Date: April 29 2025

File: 073124 - 45 Oak Street

URBAN DESIGN REVIEW PANEL REPORT - 45 OAK STREET

ÉÉP LOUISE-ARBOUR 45 OAK STREET, OTTAWA, ON

DRAWING TITLE:
FINAL SITE PLAN

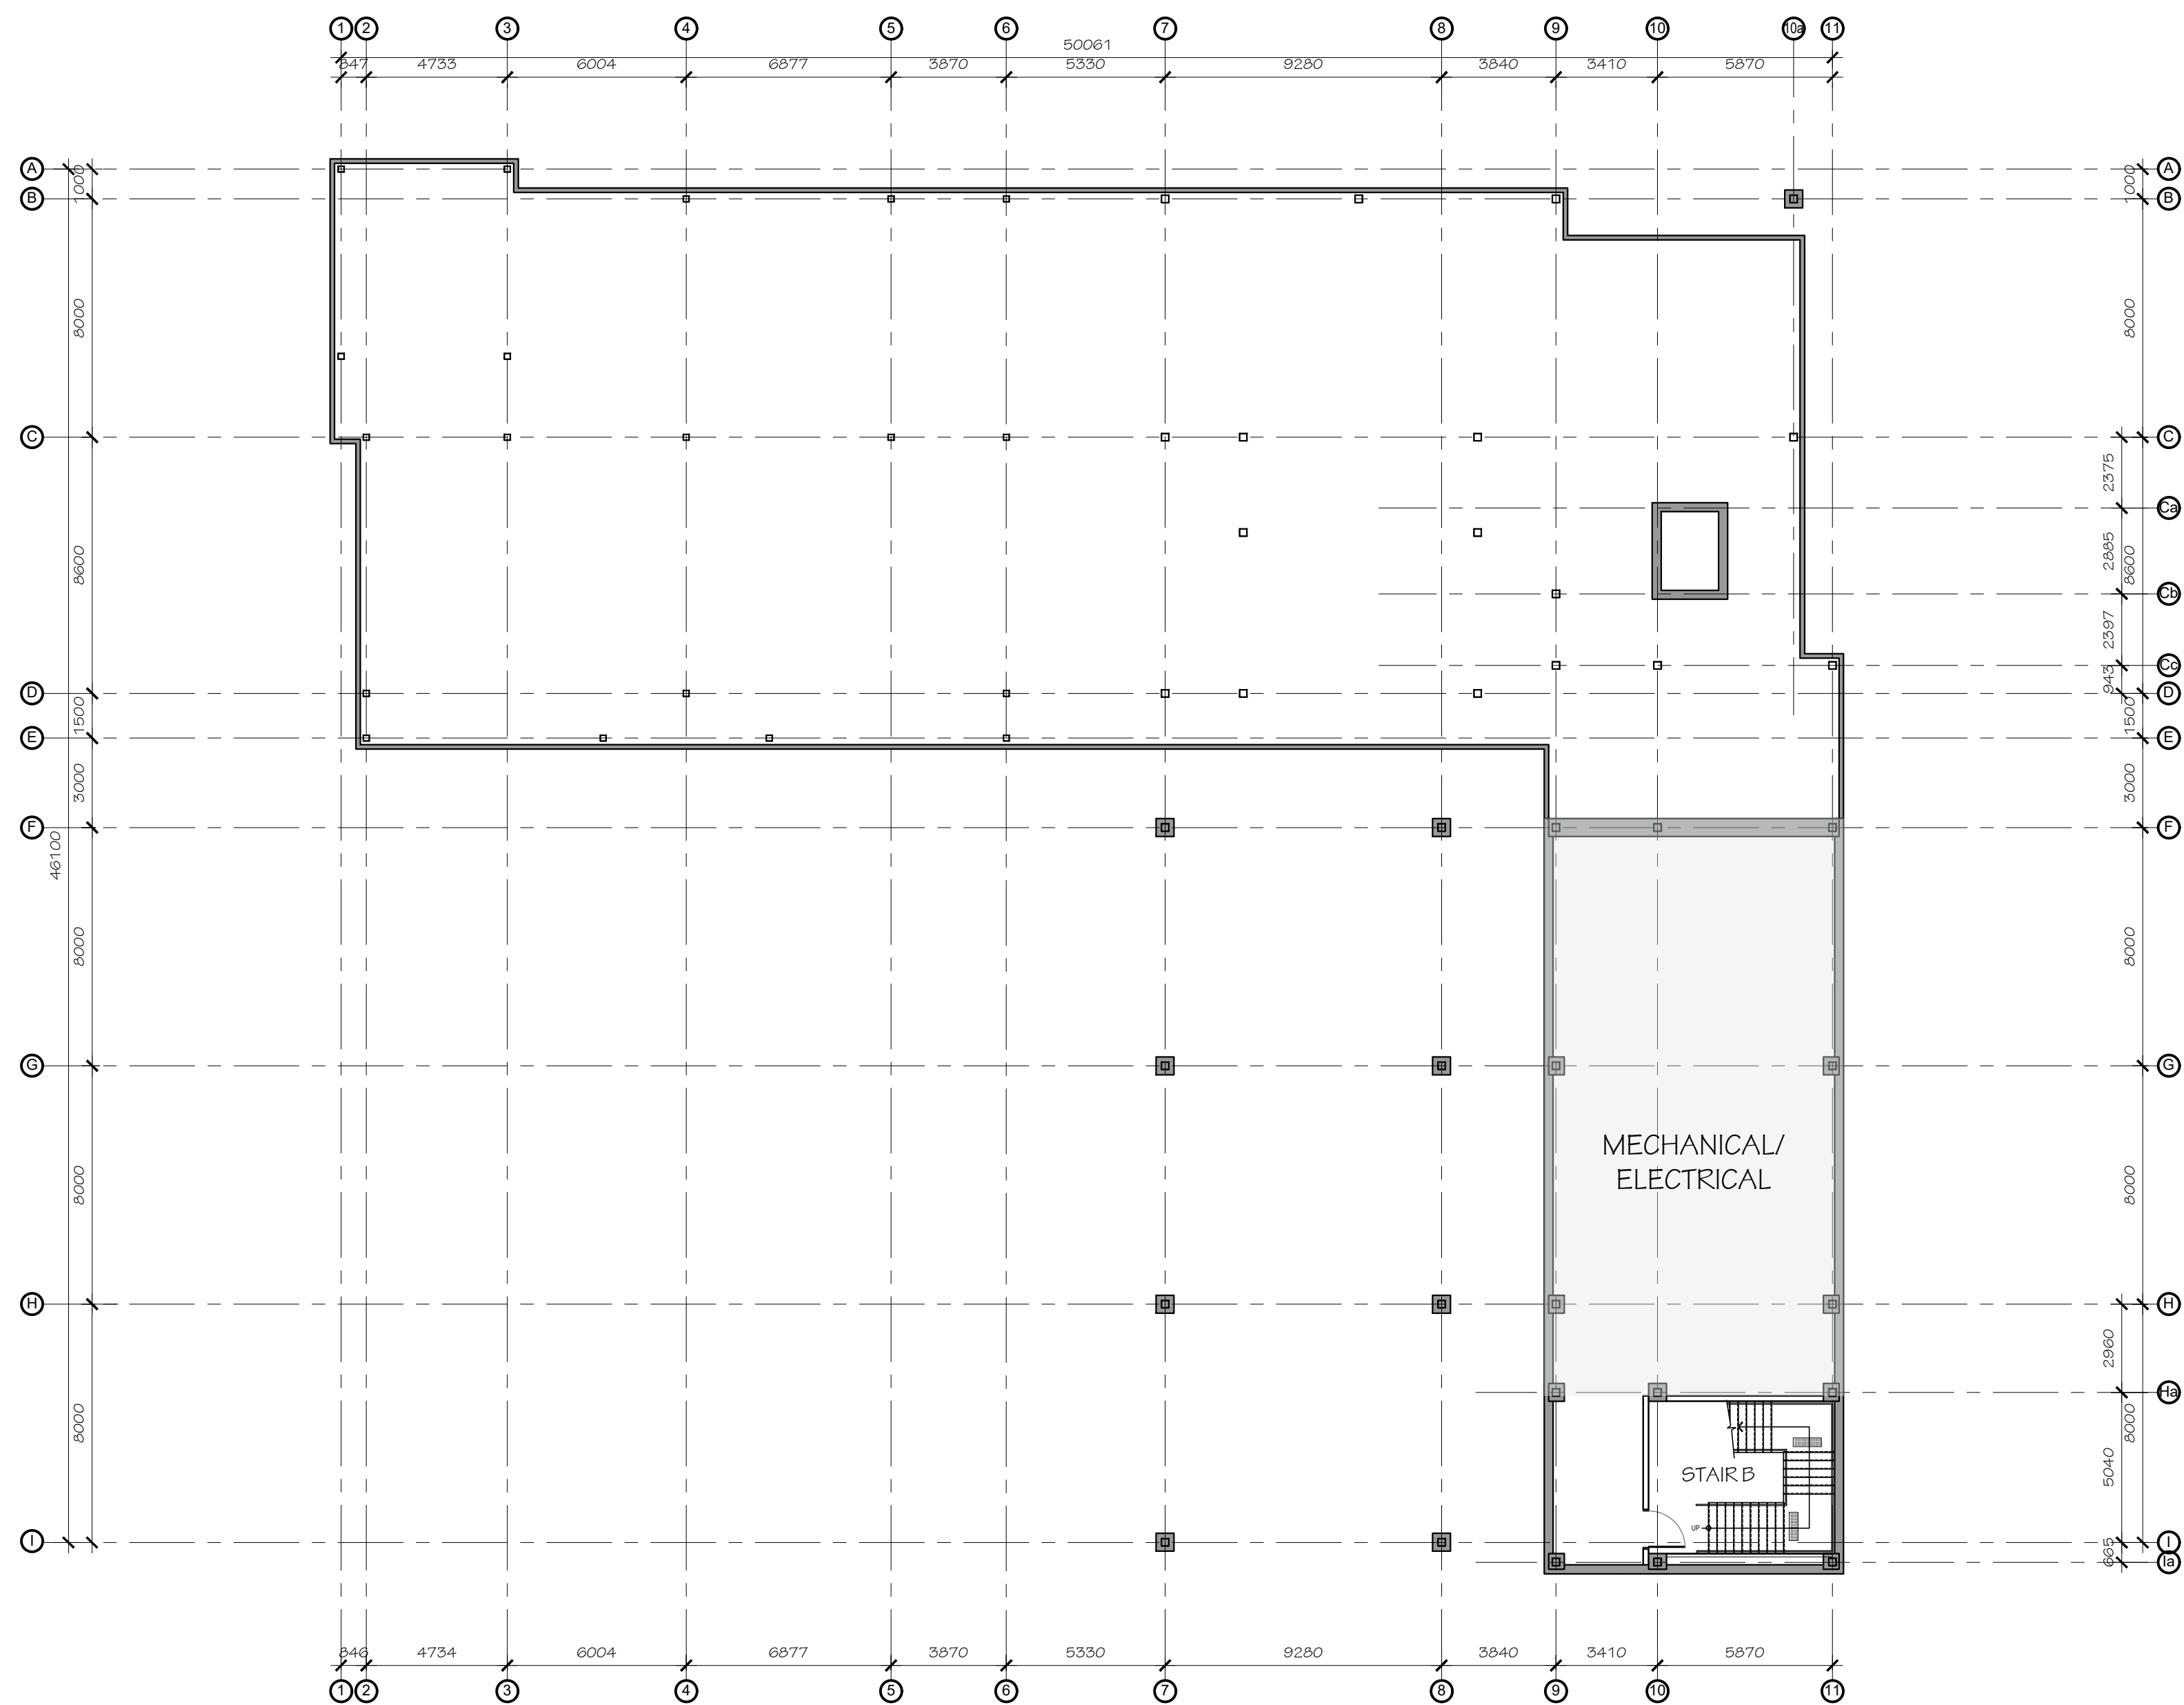
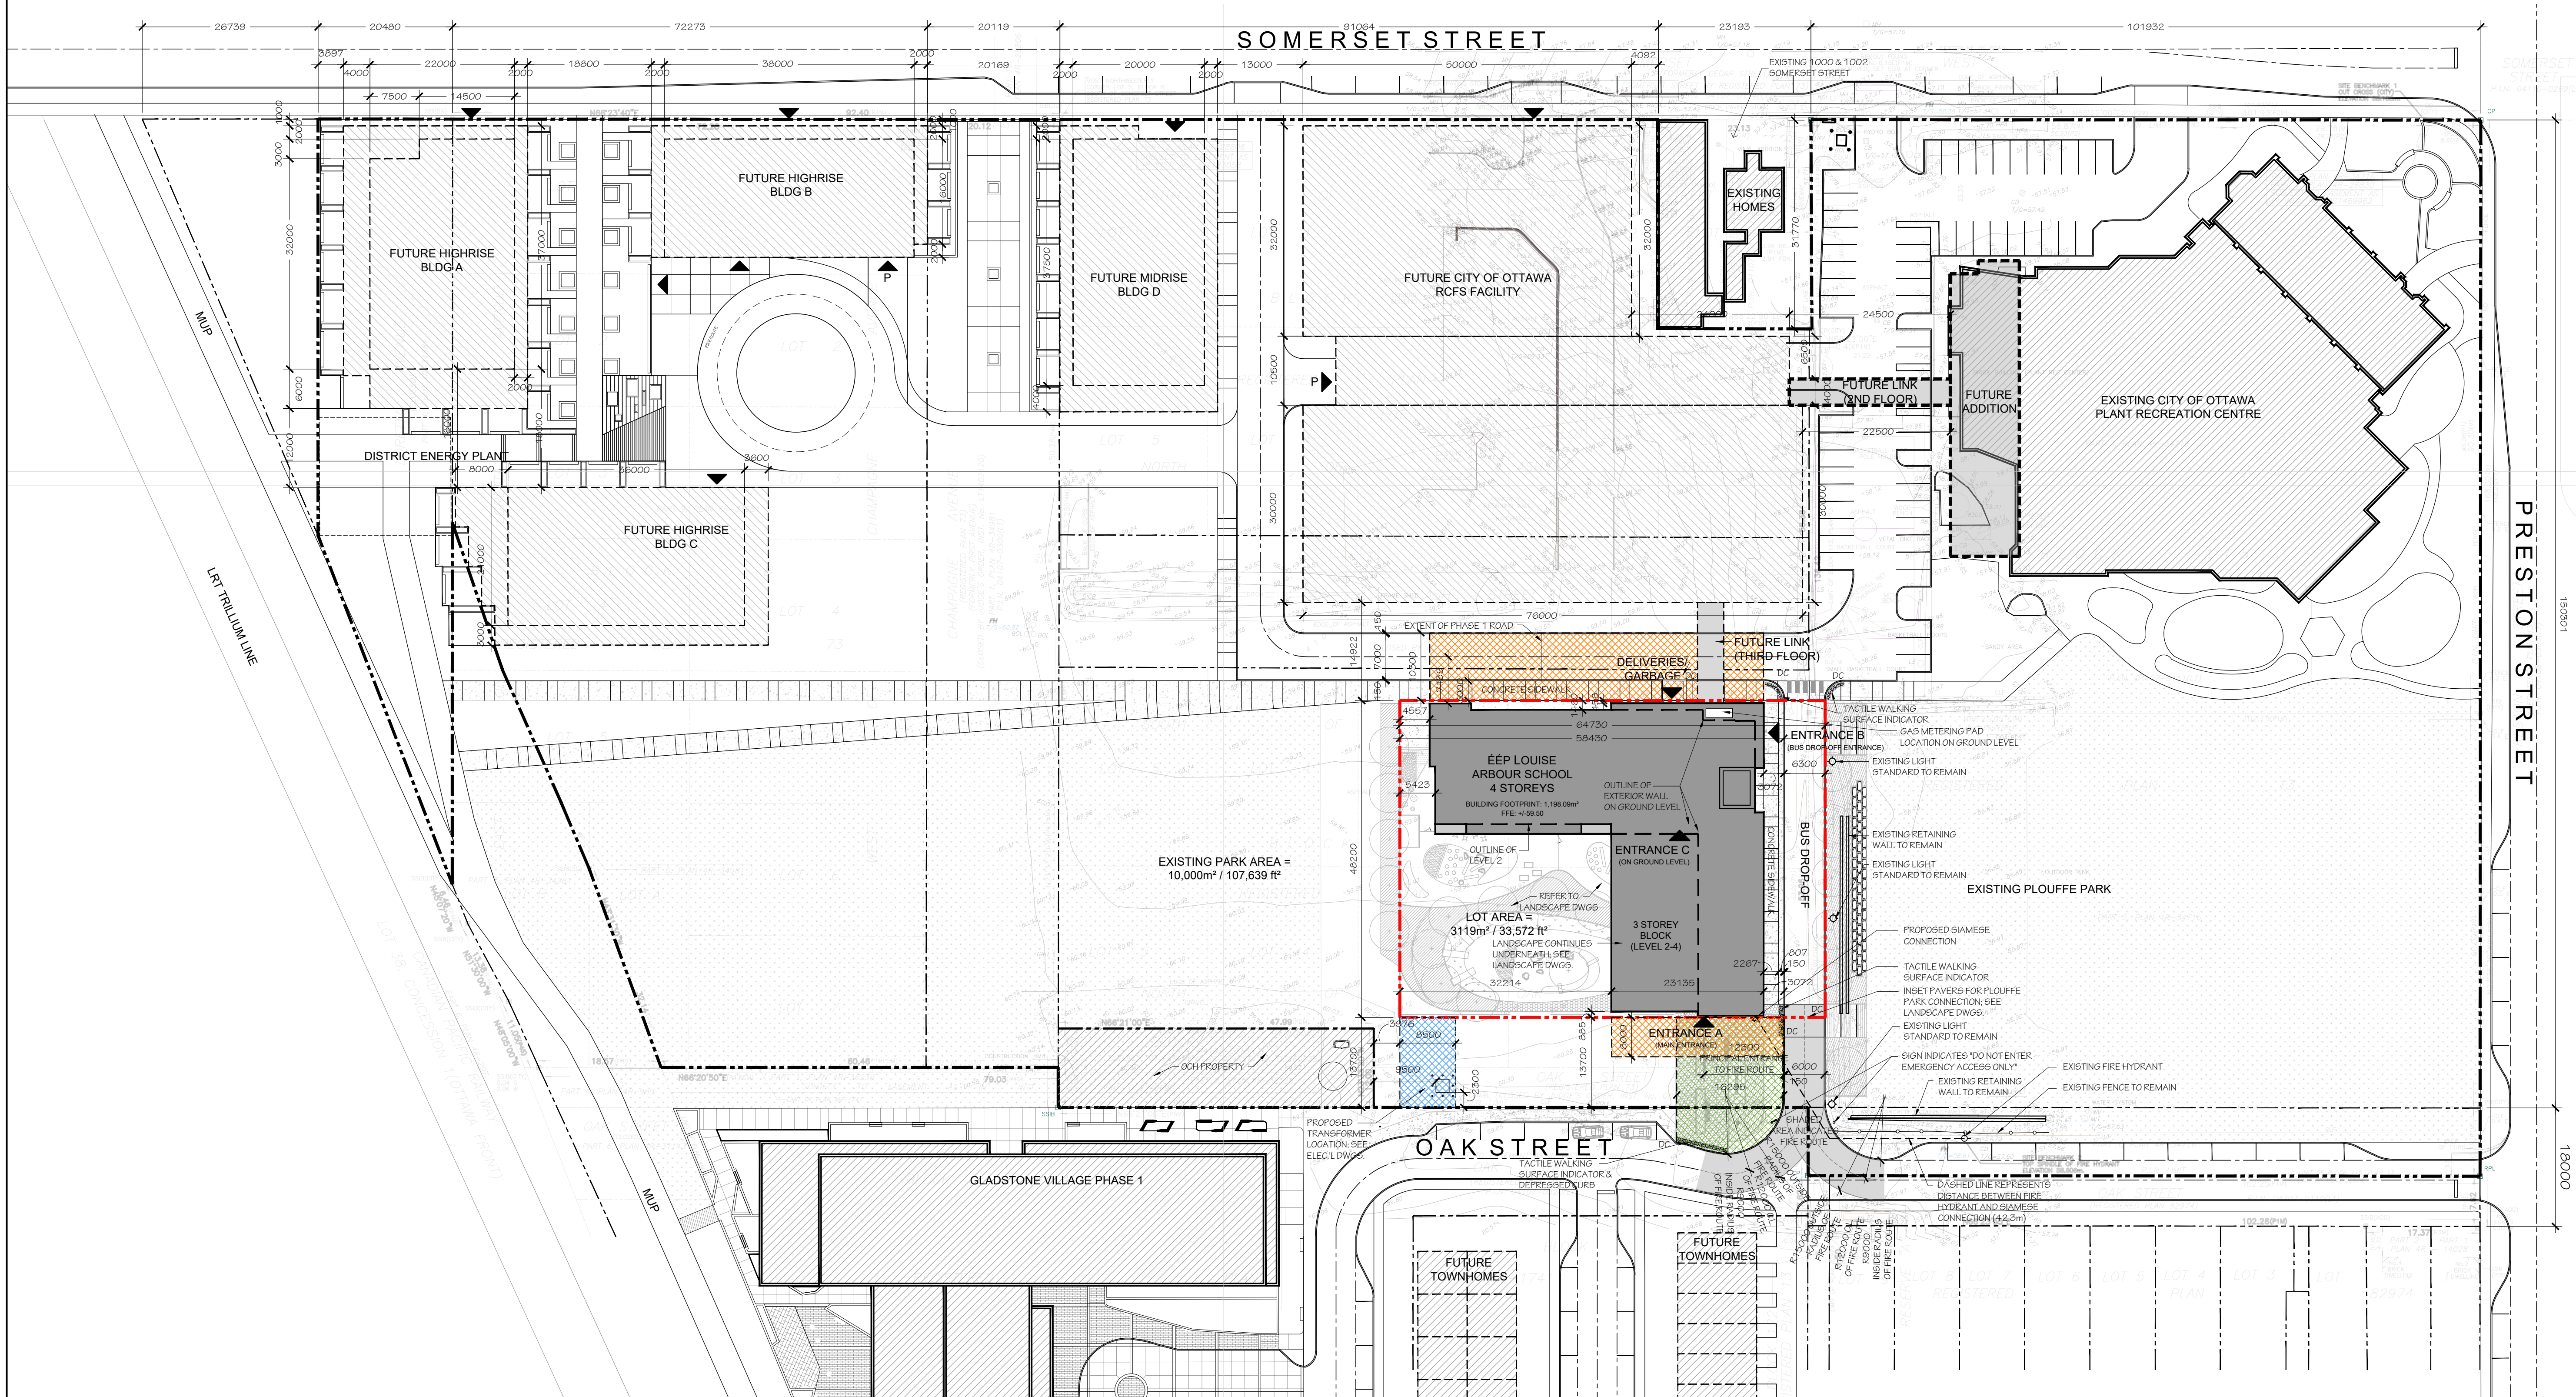
(5 of 25) The Panel raised concerns regarding the school entrance, bus drop-off, and vehicular integration, and encouraged the design team to continue exploring solutions.

- A suggestion was made to consider placing school buses further away from the school to allow for a short walk, referencing traditional school arrival experiences that could benefit the morning routine and enhance the public realm.
- The recommendation is appreciated and various options have been reviewed for the bus route and safe drop off and pick up of students. The proximity of the bus drop off space to the school is important to address safety concerns with primary school-aged children and minimizing the distance they must walk. Further, demarcation of the school bus zone may provide future opportunities for useable amenity space for school and/or park events in off-school times and seasons.

(13 of 25) The Panel has concerns with having the school surrounded by roads on three sides and recommends considering future phasing options to improve school connectivity and reduce vehicular adjacency for children safety.

(14 of 25) The Panel supports a thoughtful approach to border conditions and stresses the need for safe and seamless connections between the school, adjacent streets, and the park.

While the area to the north of school is traversable, it will not be a heavily trafficked area and further, it is not a main entrance for student use and as such will not be a factor for conflicts with students and vehicles at this location. The bus route on the east side of the school is for bus traffic only and will not be used by regular vehicles. It will be controlled specifically for student safety. When bus activity is absent, the section for bus drop off will function as a pedestrian connection to Plouffe Park. Some form of control will be in place to prevent vehicles from driving into the section of bus lane directly east of the school. Further, Oak Street to the south is separated from the school by a section of City park land that will create a suitable buffer during before and after school pickups and drop-offs. While there are roads in place around the school, their functions and the school entrances for students are designed in such a manner that conflict for students will be extremely minimal.

Safety is always a primary consideration in the planning of school site and the position of sidewalks and connections to the park and the rest of the hub and surrounding neighbourhoods. The connections through the hub and around the school are designed to facilitate easy connectivity and design with the future park designs. Both planning teams will continue to work with staff moving forward to ensure that the area is designed and coordinated with seamless integration of design in mind.
